**REQUEST**

Current Zoning: UC (uptown core)  
Proposed Zoning: UMUD-O (uptown mixed-use development, optional)

Approximately 2.73 acres bound by the south side of South College Street, west side of East Martin Luther King Jr. Boulevard, north side of South Brevard Street, and east side of East Brooklyn Village Avenue.

The petition proposes to allow all uses permitted by-right and under prescribed conditions in the UMUD zoning district on a parcel currently developed with office uses.

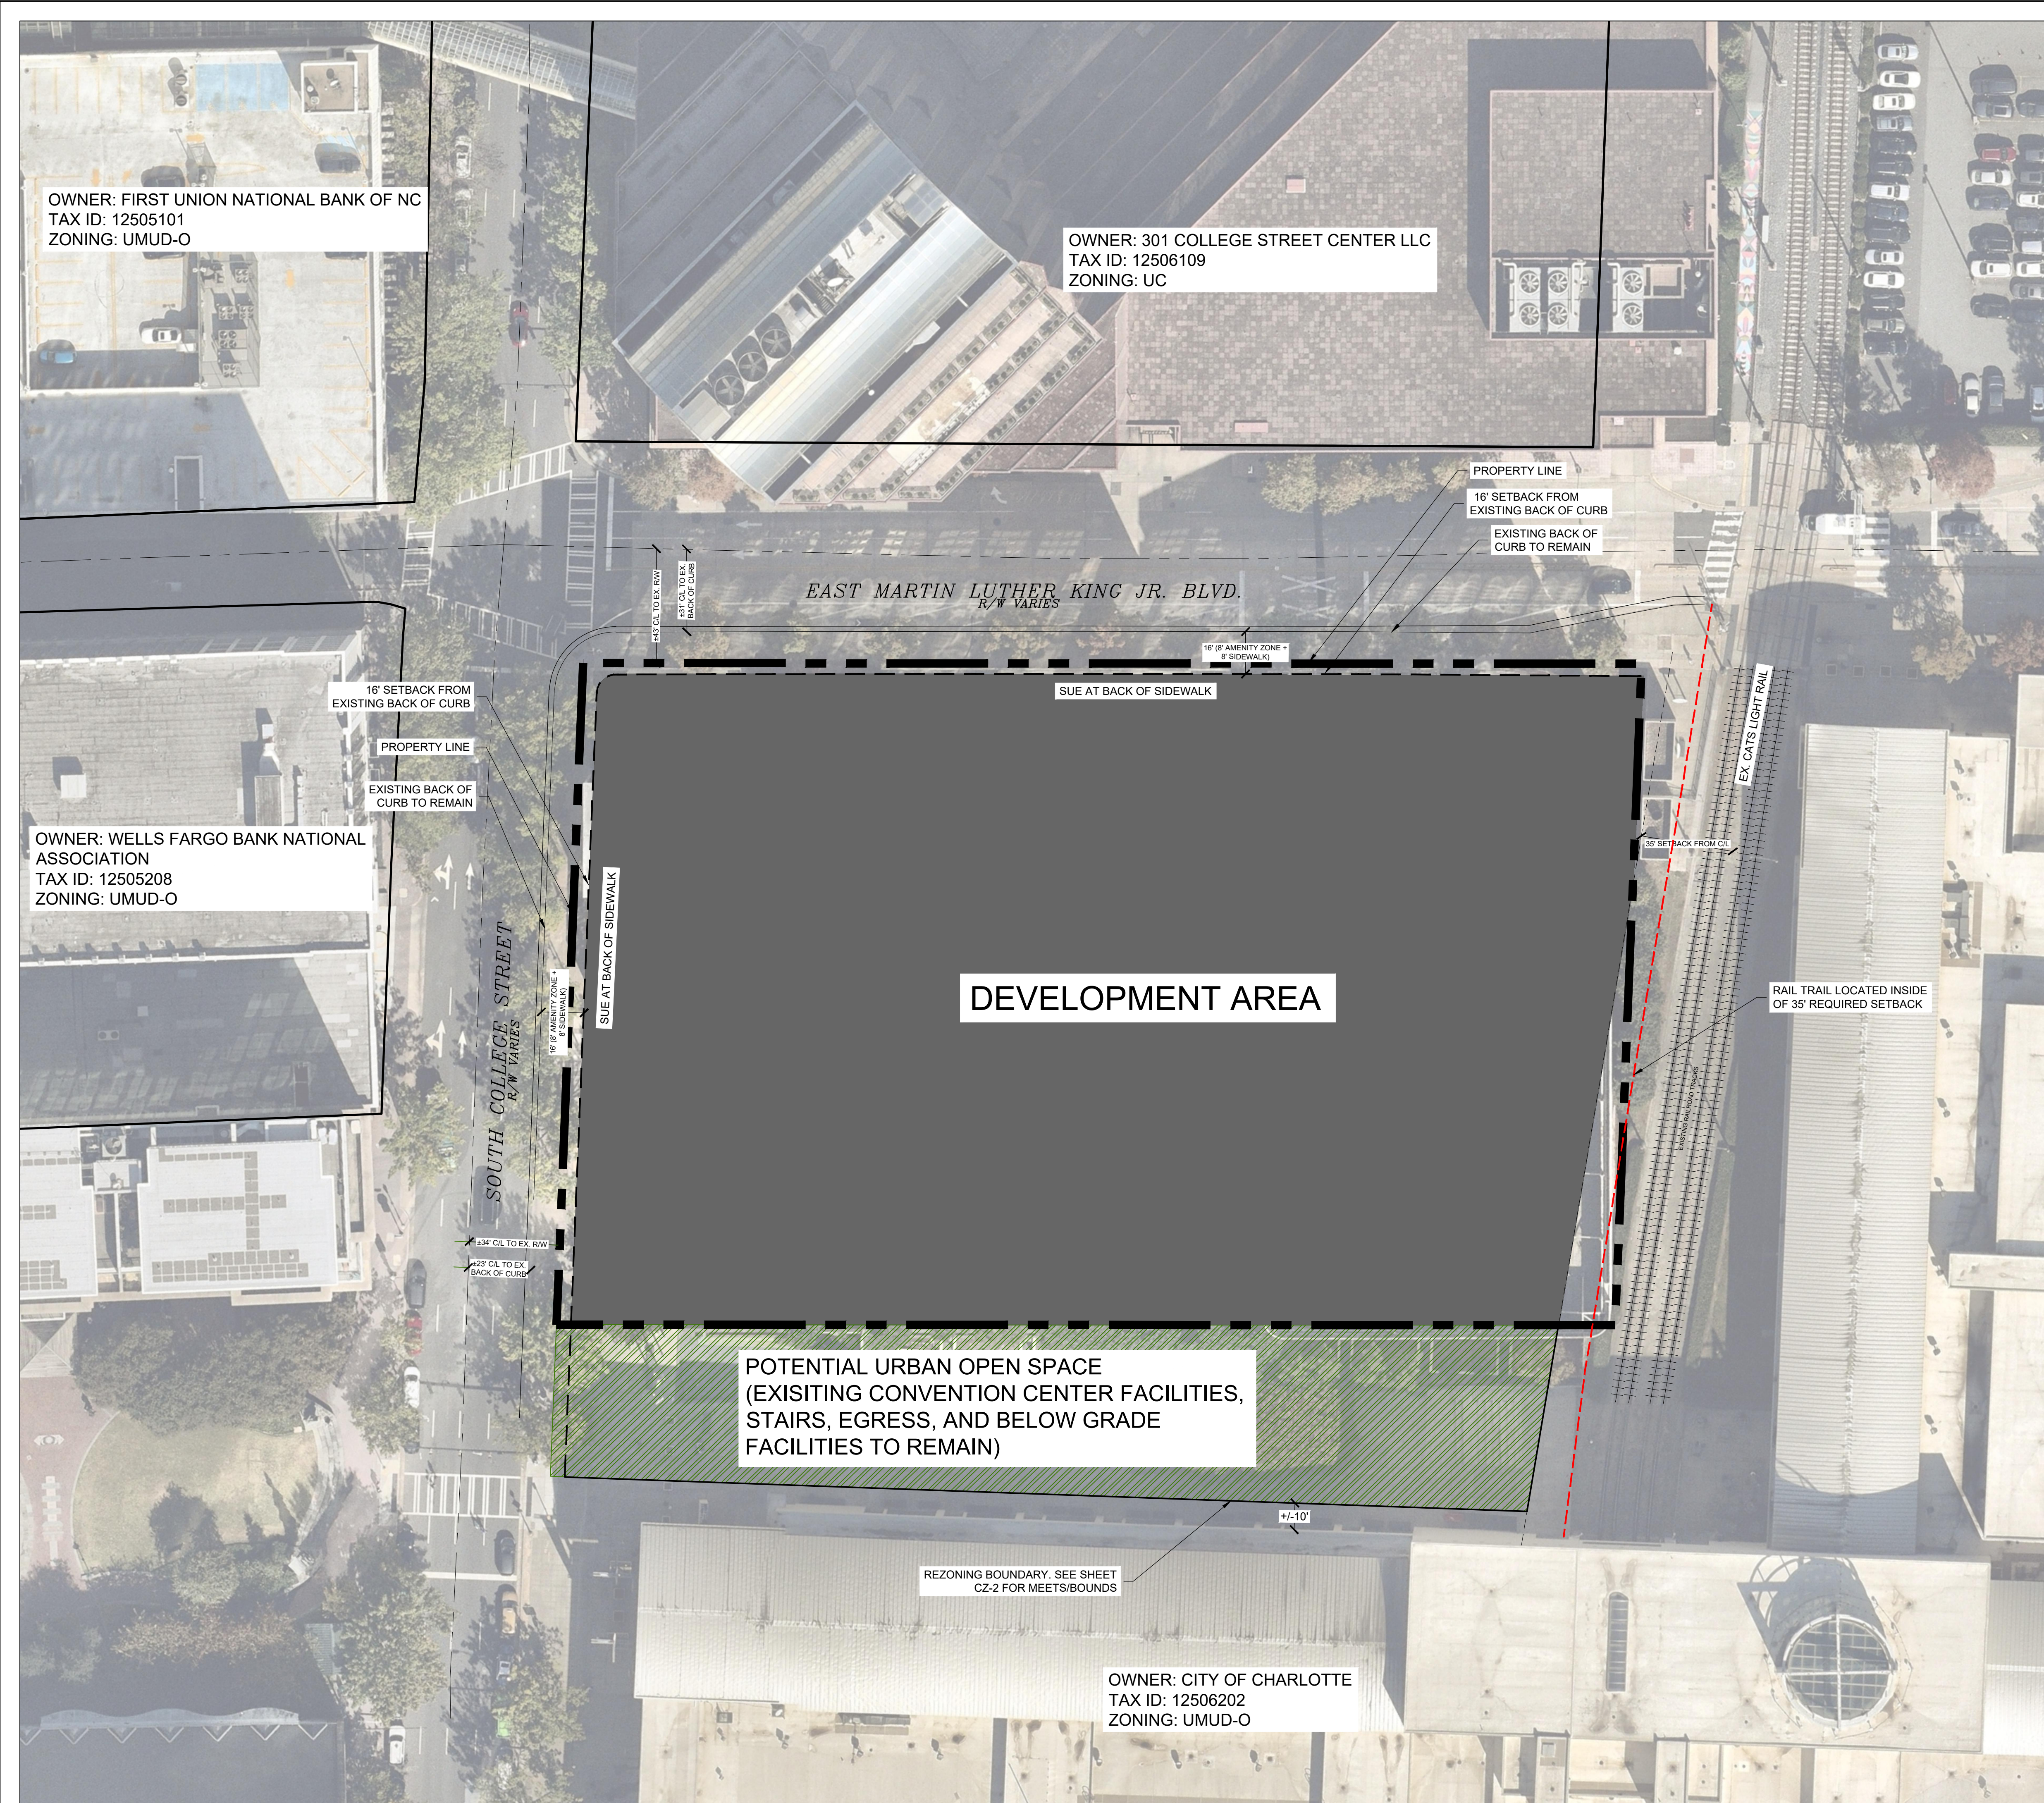
8. ~~Remove site plan callout and other references stating that the existing convention center facilities along the Rail Trail corridor will be relocated by others.~~ **Addressed**

9. ~~Show proposed locations of valet parking on the site plan.~~ **Addressed**

10. ~~Clarify in the conditional notes what portion of the rail trail the petitioner will construct and what pedestrian improvements will be incorporated.~~ **Addressed**

- Commits to construct a portion of the Rail Trail along the site's frontage. ~~contingent upon the Convention Center removing utility boxes from the corridor and the Convention Center constructing the portion of the Rail Trail from the Convention Center to the existing terminus as Brooklyn Village Avenue.~~

- Commits to improve accessible ramps at all four corners of College Street and Martin Luther King JR. Blvd. and will install accessible pedestrian signals at the intersection subject to right-of-way availability.

- Provides space for a future bus stop within the pedestrian amenity zone on South College Street.
- Notes that streetscape and roadway improvements will occur in tandem with development along each frontage.
